The application site, whilst not within the Angmering Conservation Area, is located immediately adjoining it. The scale and nature of the proposal is such that it is considered to have an effect on the setting of the Conservation area.

David Wilson Homes
Angenighting
client: Barratt David Wilson
drawing: Soft Landscape Proposals
date: July 2012
scale: 1:200@A1
drawing no: BSH 17576 12A
drawn: DKM checked: AW

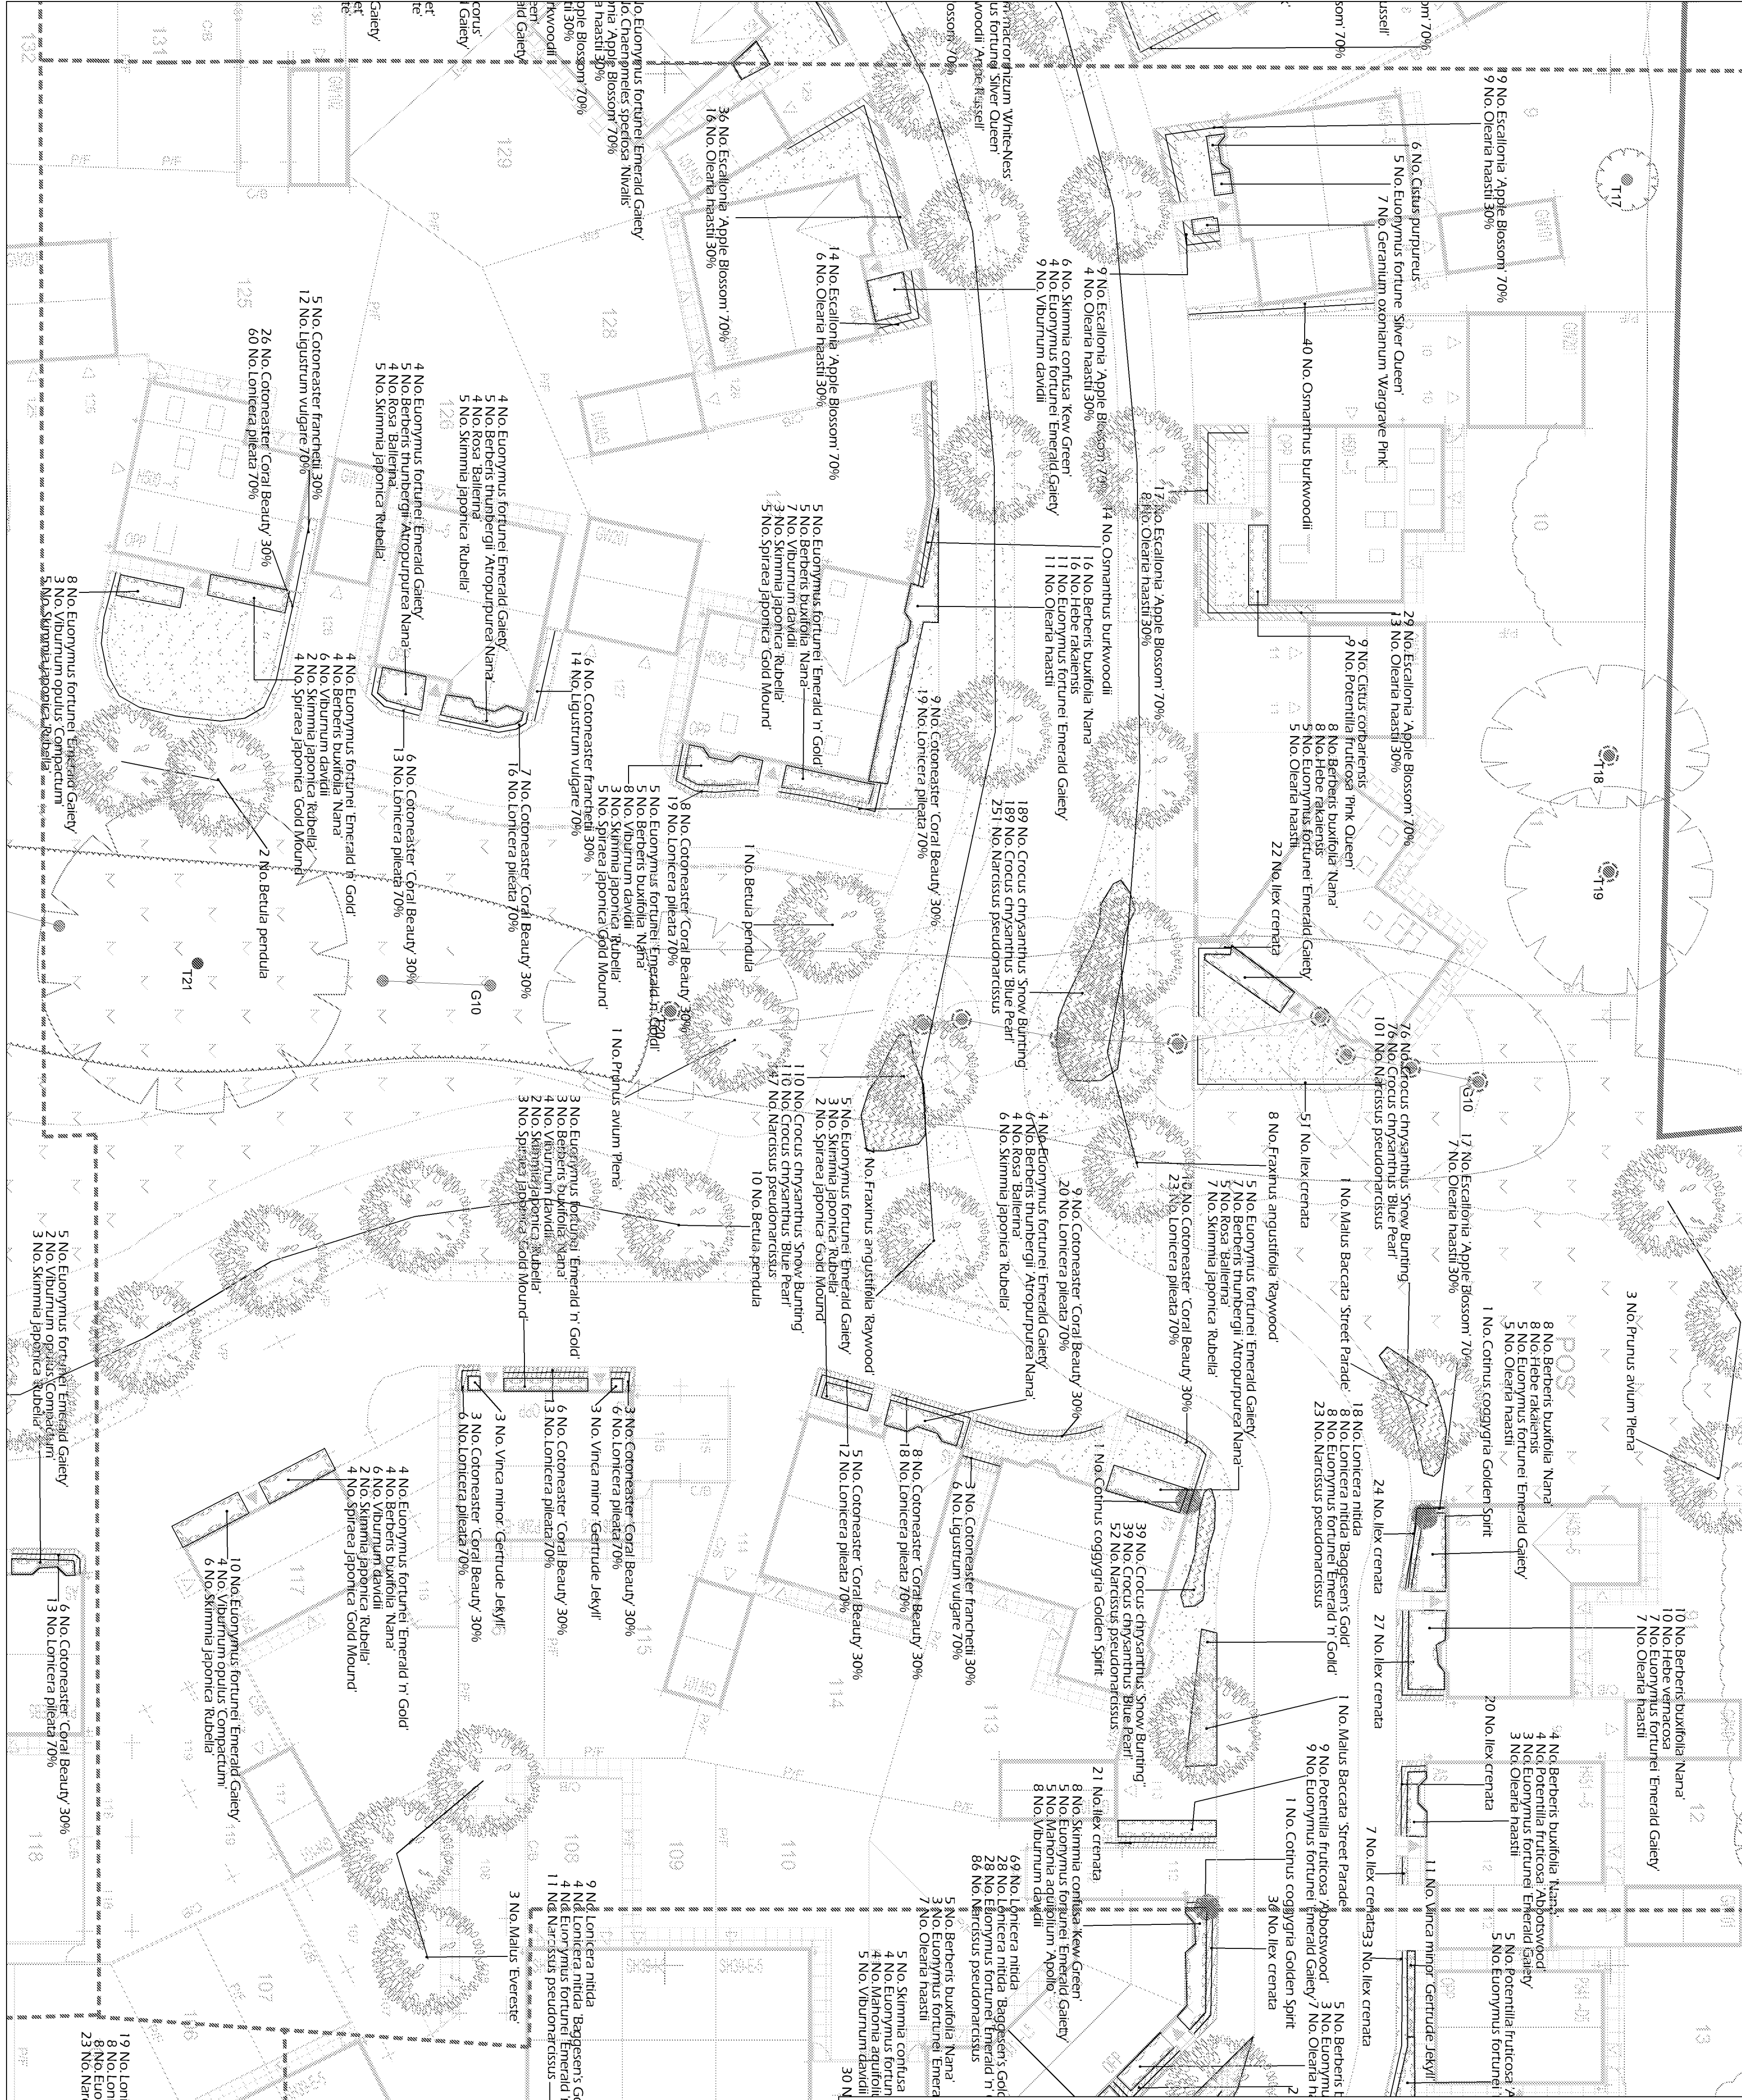
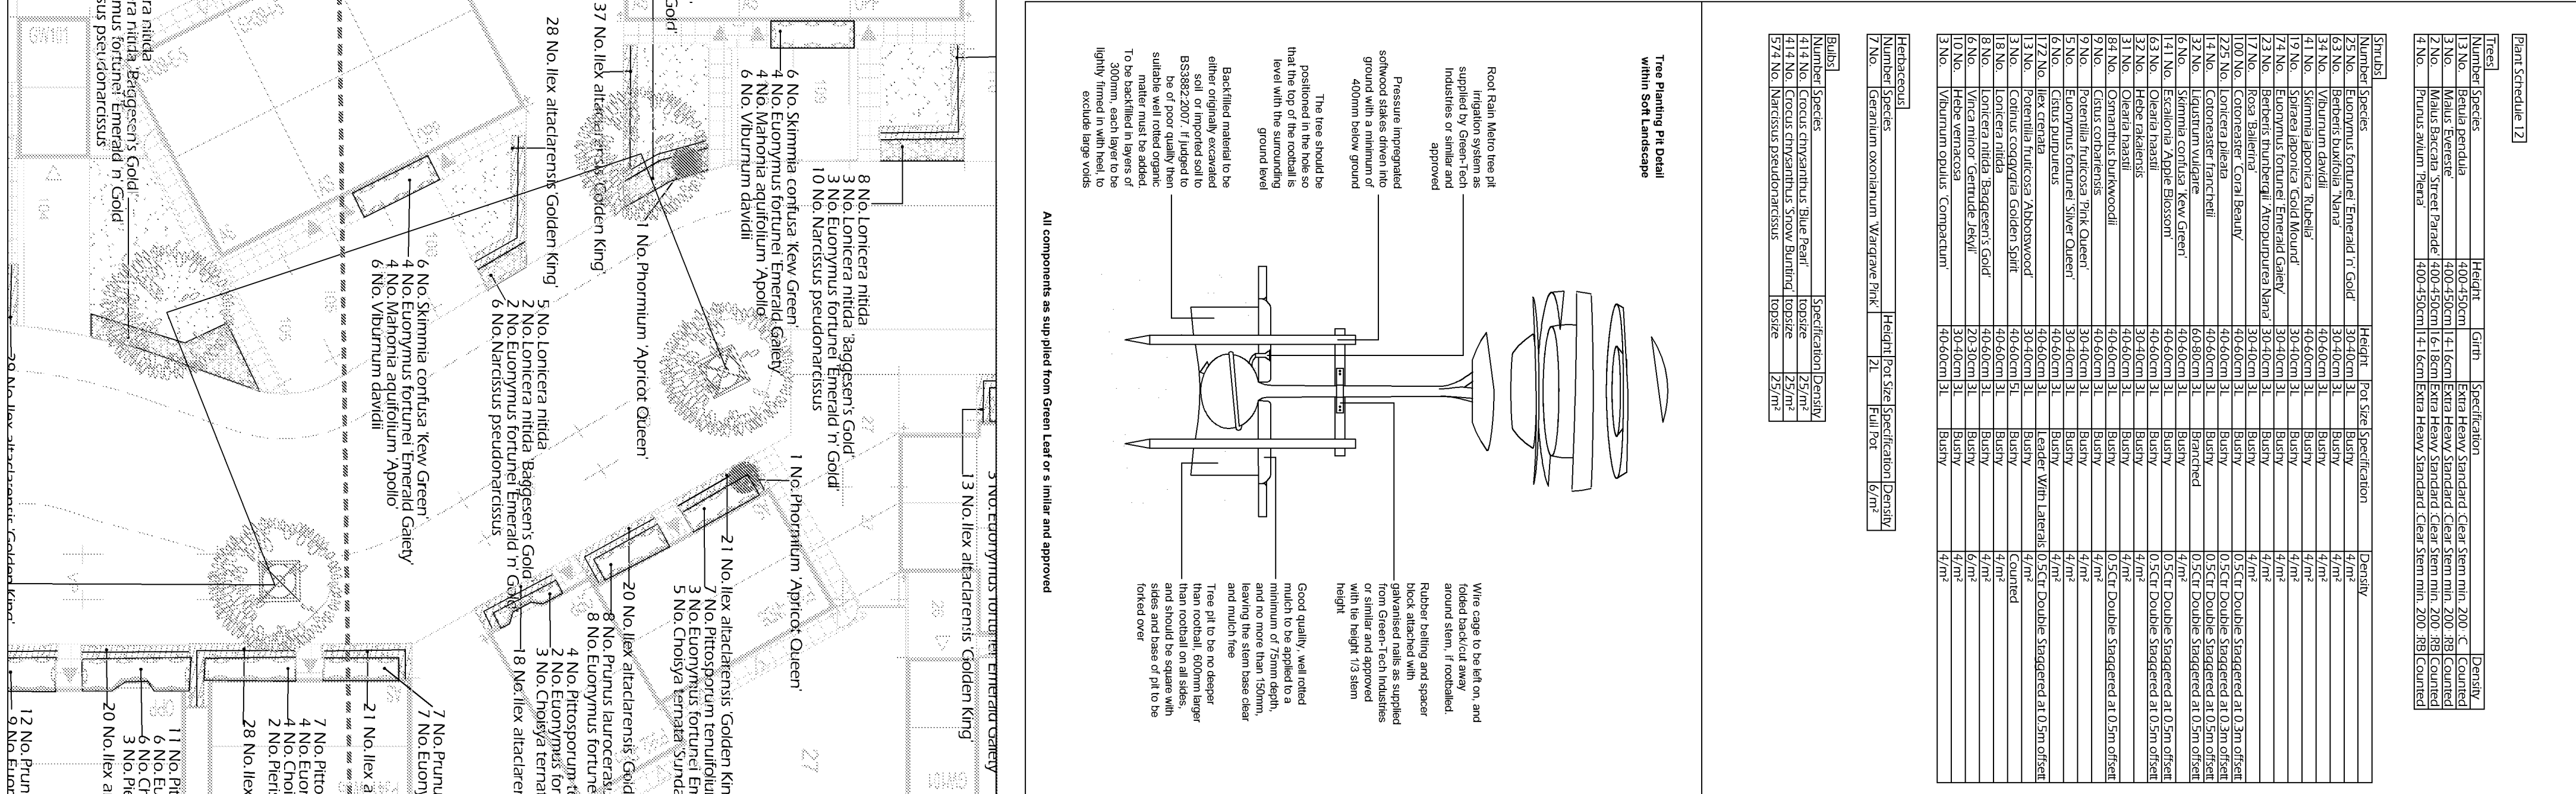
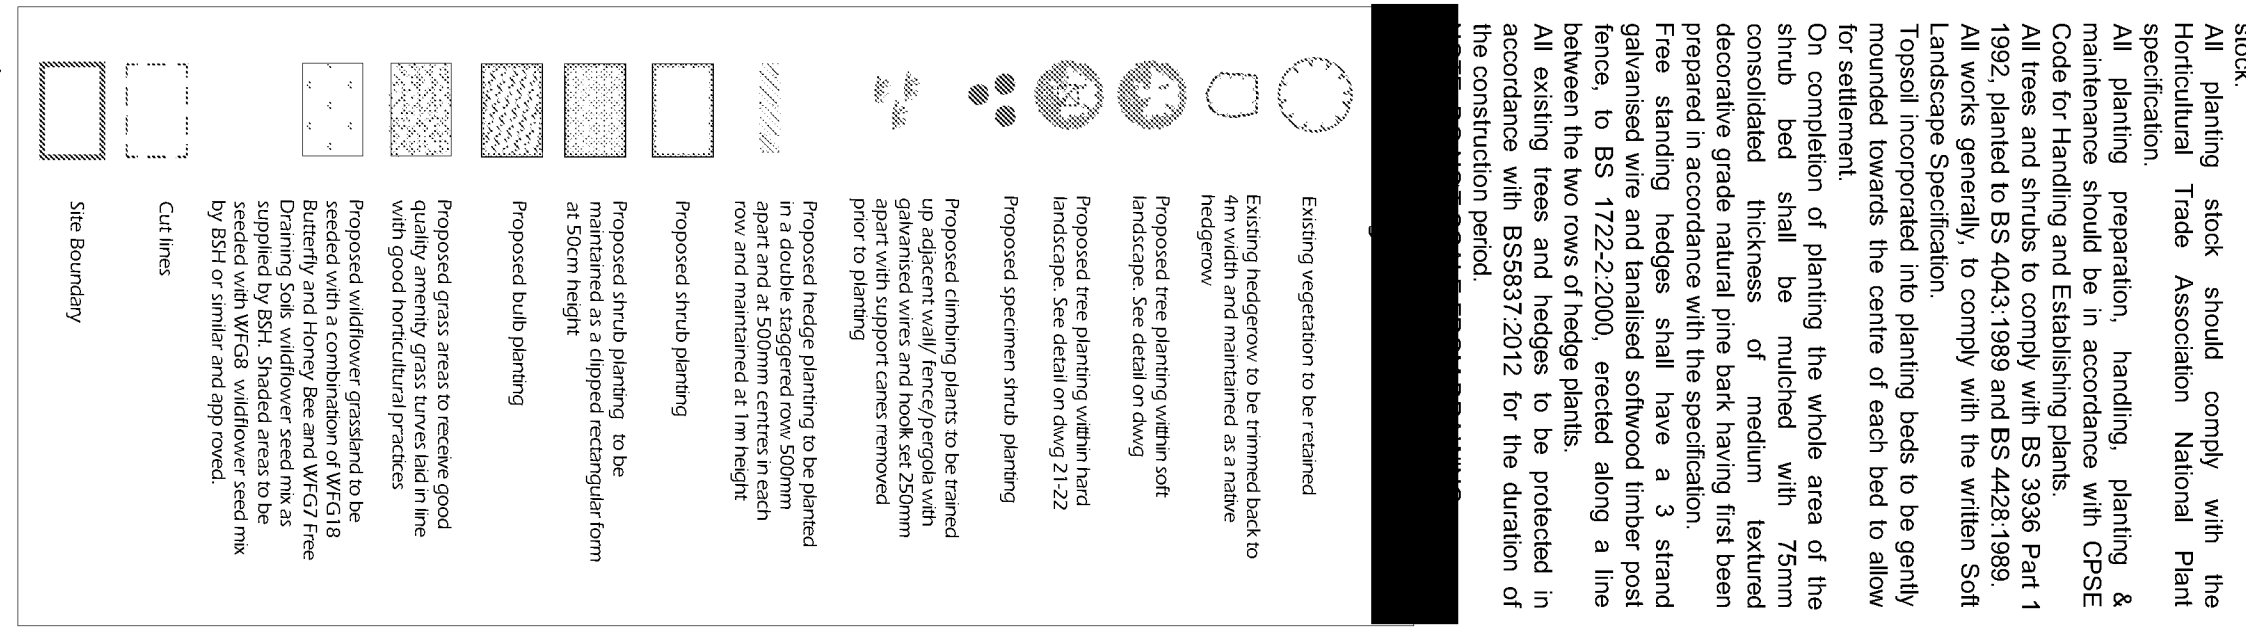
The proposal seeks to retain a number of trees and hedges along the northern and western boundaries of the site. Boundary landscaping is particularly important along the western street frontage where, in its absence, the development would have the potential to be viewed from the edge of the conservation area. Therefore, this concept of retention is supported.

It is also noted that there is a fair amount of planting outside of the proposed development boundary to the north which has the effect of limiting the direct impact of the development on the scheme.

The level of vegetation provision to the north of the site (both within and outside of the ownership of the applicant) and along the western boundary, means that the impact of the proposal will be minimal, and therefore of no concern.
